Your Ref: MP05_0129 PMA-380

Re: MP05_0129 Lakes Estate Residential Subdivision, North Boambee Valley, Coffs Harbour Local Government Area

Reference is made to the above Major Project and your letter of 30 April 2020. Thank you for the opportunity to review draft consent conditions. Suggested edits to draft consent conditions are listed below:

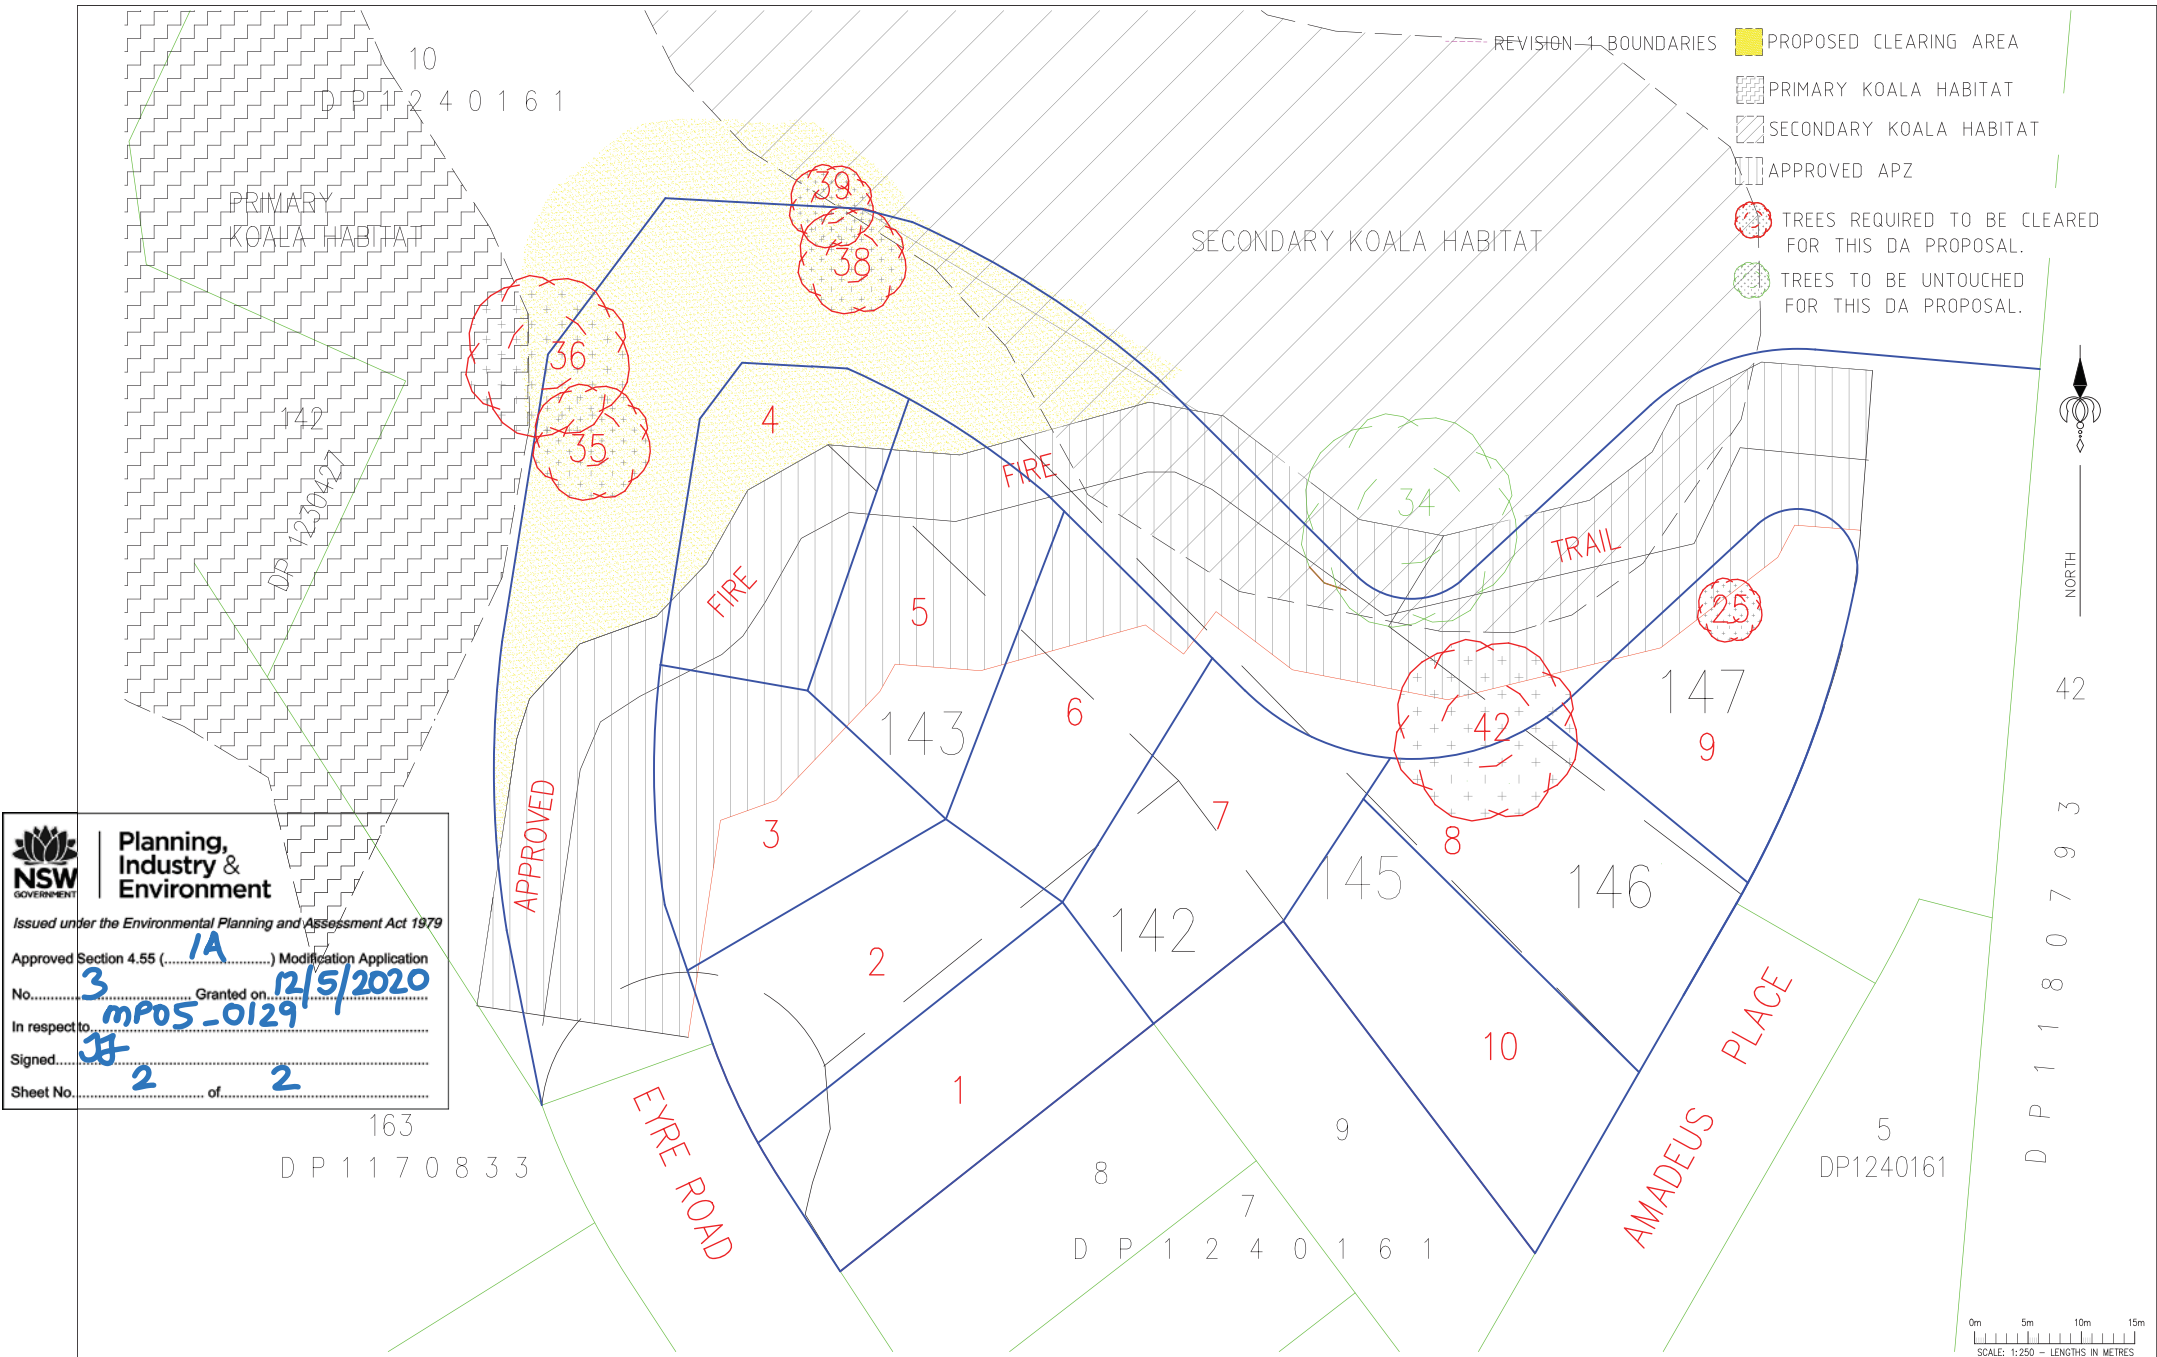
A5A	Amended Stage 3A Plans
	<i>Amended plans shall be submitted to and approved by Coffs Harbour City Council prior to the issue of any Construction Certificate for works in Stage 3A approved under MP 05_0129 MOD 3, showing:</i> <i>a) the public road around the perimeter of Stage 3A (extension of Eyre Road) designed to include a verge width and maximum grade and speed to radius relationship in accordance with AUS-SPEC – Standards Australia.</i> <i>b) the extension of Amadeus Place (connecting with Eyre Road) designed to include:</i> <i>• an 8m wide carriageway in accordance with Planning for Bushfire Protection</i> <i>• the verge slope in accordance with Council's standards (maximum slope 1:4 fill and 1 cut) and Austroads- Guide to Road Design Part 6.</i> <i>Any amendments to road or lot layout to meet the above road design requirements must not require the removal of any additional trees or koala habitat and must not impact on the protection of Tree 34 (as shown on Proposed Subdivision Lot 10 DP 1240161, dated 27.03.20) as outlined in the Arborist Report.</i>

Reason:	Re: Item (a): The residential neighbourhood is already a very low speed environment. It is not necessary to design for 50 kph as this speed is (a) undesirable in this location and (b) impossible to achieve due to road geometry in the lead up to the proposed extension of Eyre Road. The Eyre Road extension adjoins Public Reserves (163//1170833; 142//1230427 and 42//1180793), consequently, low speeds are preferred for increased wildlife safety and to maintain a quieter 'play street' environment. The Eyre Road extension meets Aus-spec criteria for an access street being ...<i>the lowest order road (access street) having as its primary function, residential space - amenity features which facilitate pedestrian and cycle movements, and where vehicular traffic is subservient in terms of speed and volume, to those elements of space, amenity, pedestrians and cyclists.</i> Eyre Road is identified in the North Boambee Valley East Developer Contributions Plan as a minor road (see extract attached). Re: Item (b): Austrroads- Guide to Road Design Part 6 references batter slopes of no greater than 1:4.
